Recommendation Report for Planning Permission for Works or Extension to a Dwelling

REF NO: LU/218/17/HH

LOCATION: 5 Camelia Close
Littlehampton

PROPOSAL: First floor extension & conversion of garage (re-submission of LU/54/17/HH).

Proposed Front Elevation

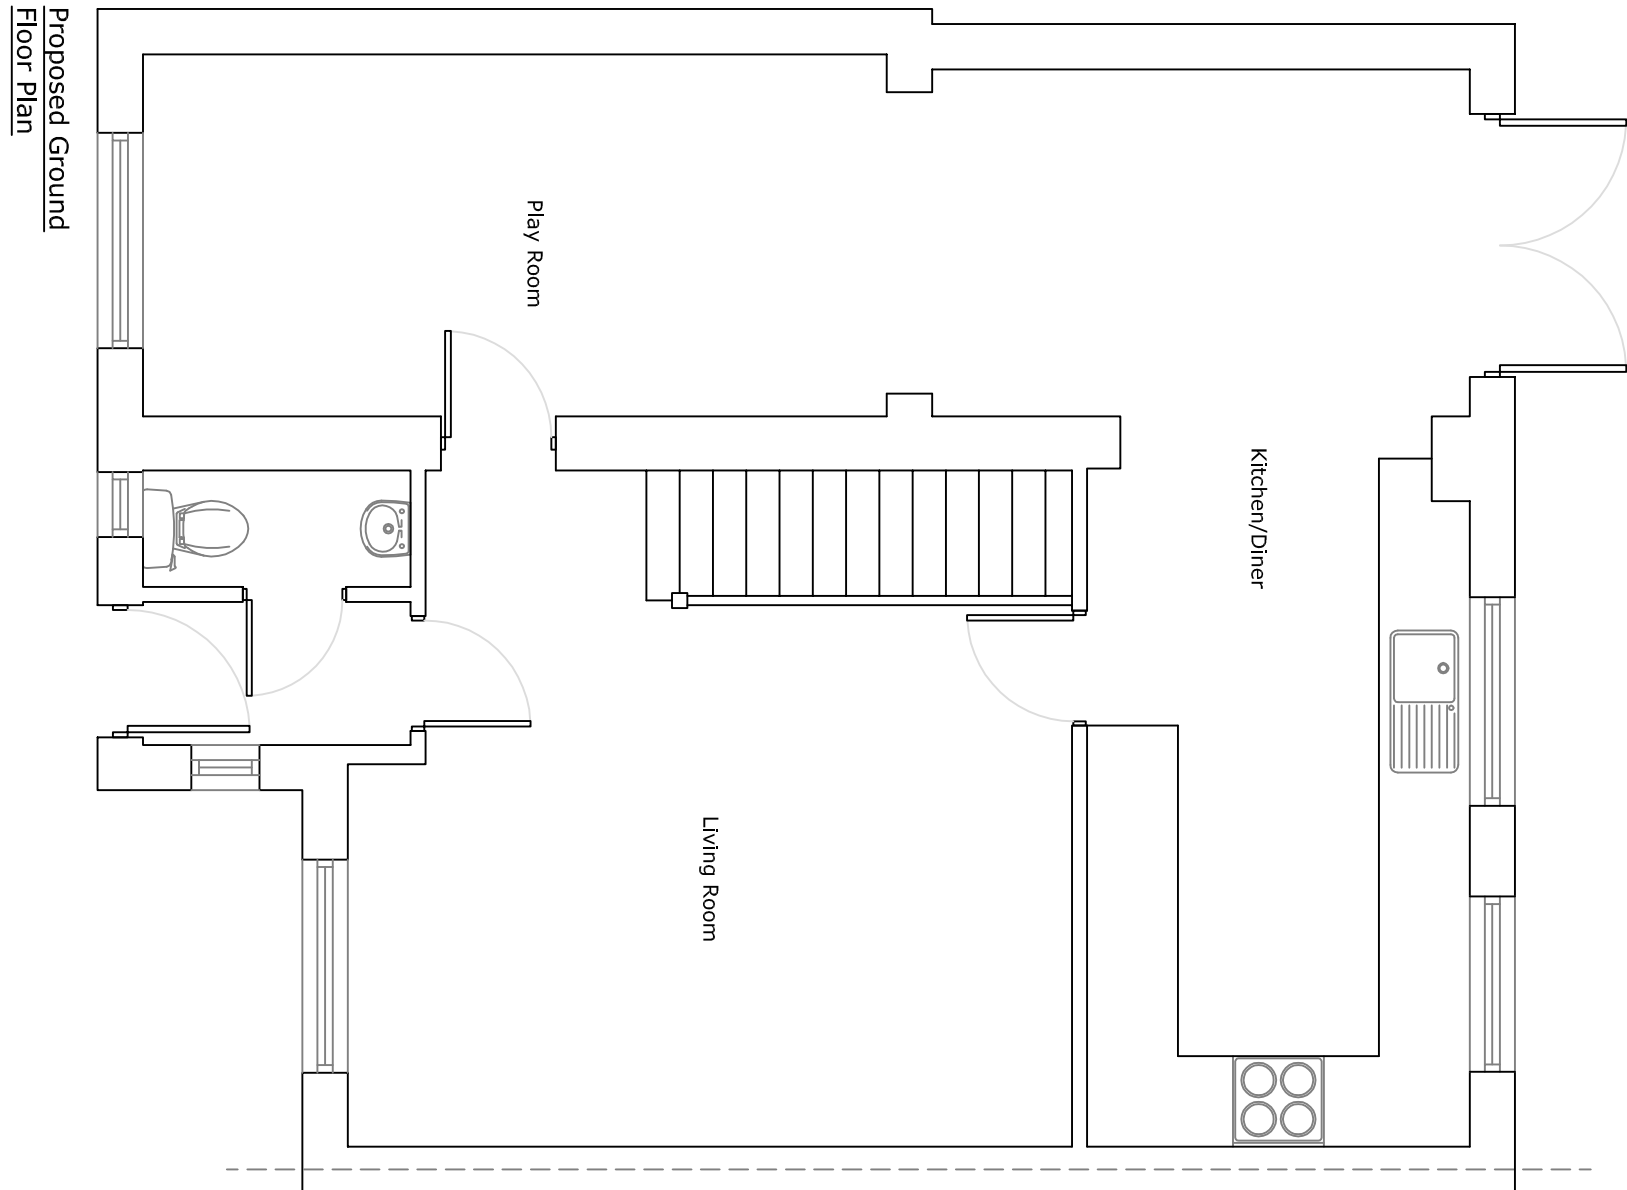
This application has reduced the ridge height of the proposal by 0.4m so that it is set down below the existing providing a more subservient appearance to the extension. The length of the extension has also been reduced to the rear by 0.9m reducing its overbearing impact on the residential dwelling to the south.

Policy DEV19 of Arun District Local Plan requires extensions to be (i) sympathetically related to and visually integrated with the existing dwelling in terms of form and scale and to be (iv) subservient to the main dwelling, The design of the extension and its height means that the proposal now meets these requirements. The proposal is therefore compliant with policy DEV19 . It would also no longer result in material harm to the visual amenities of the locality.

Proposed First Floor Plan

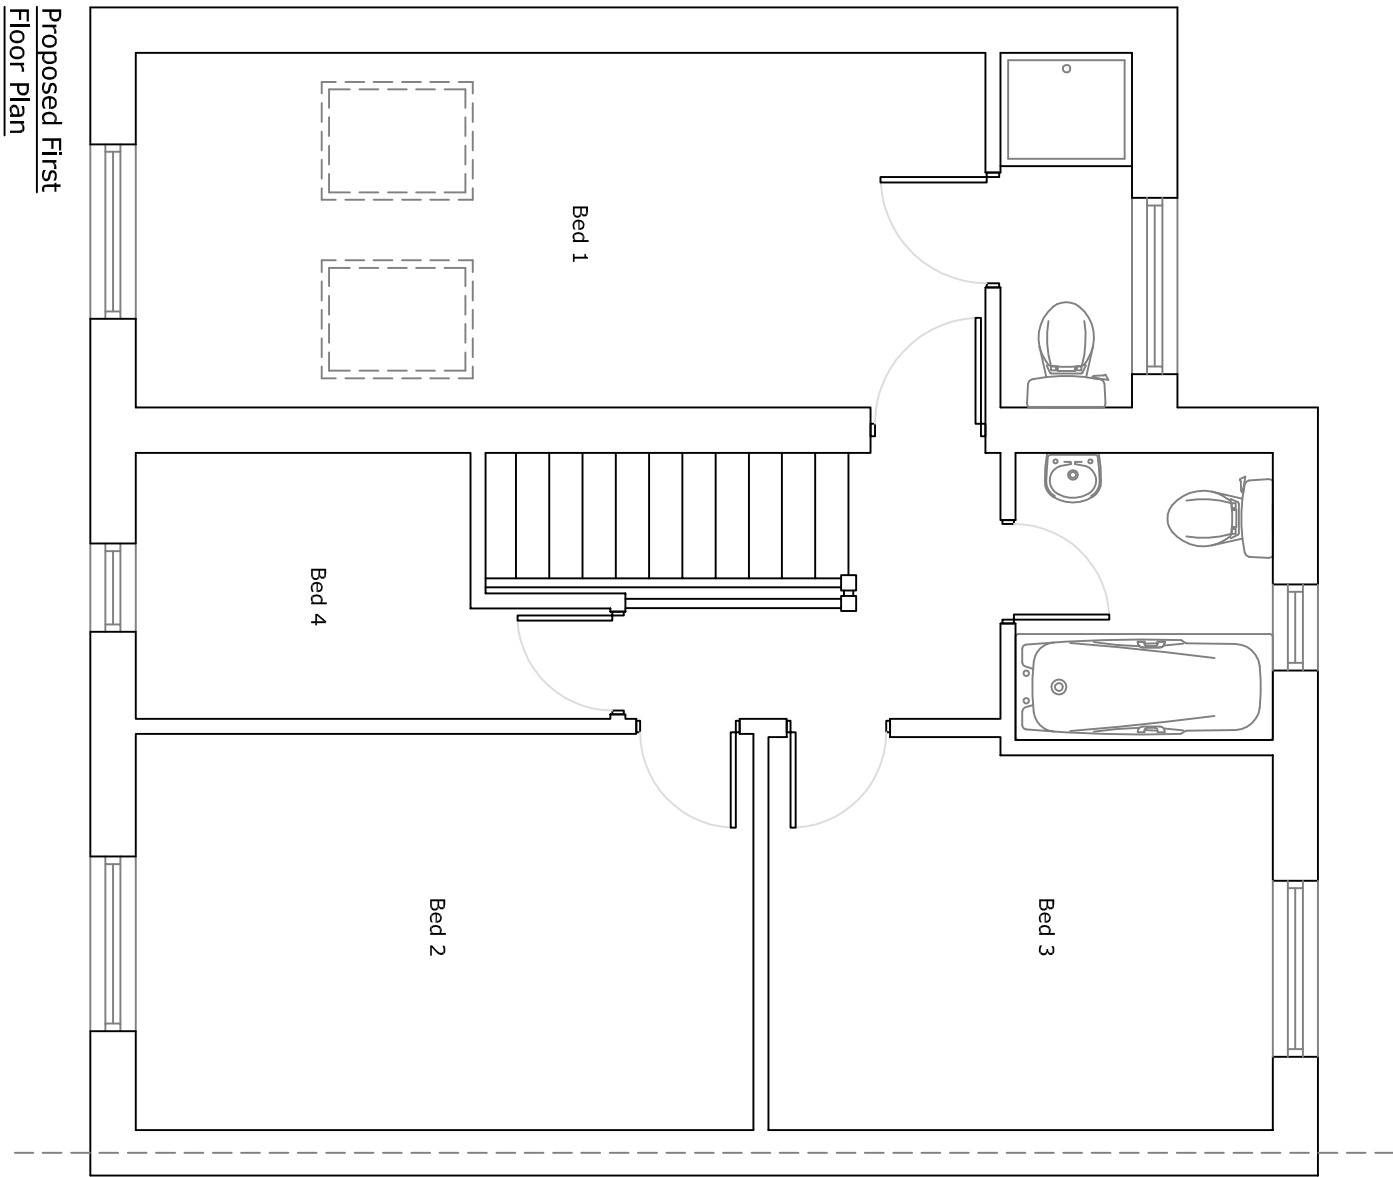
The proposed extension has no windows in its side elevation and would not therefore result in any materially adverse overlooking effects and given its height and the distance to site boundaries it is not considered that the proposed first floor extension adversely affects the residential amenities of neighbouring properties to the rear. Given its 0.9m reduction in depth to the rear, following the previous refusal it is no longer considered to be overbearing on the adjoining property to the south or its garden. The extension would be 1m from the boundary and would extend 2.4m beyond the rear elevation of the neighbouring dwelling with a height of 4.5m to the eaves which would result in materially adverse overbearing effects.

- 4 Notwithstanding the provisions of the Town and Country Planning (General Permitted Development)(England) Order 2015, (or any Order revoking or enacting that Order) no first floor windows or other openings shall be formed in the south side wall of the extension without the prior permission of the Local Planning Authority on an application in that behalf.
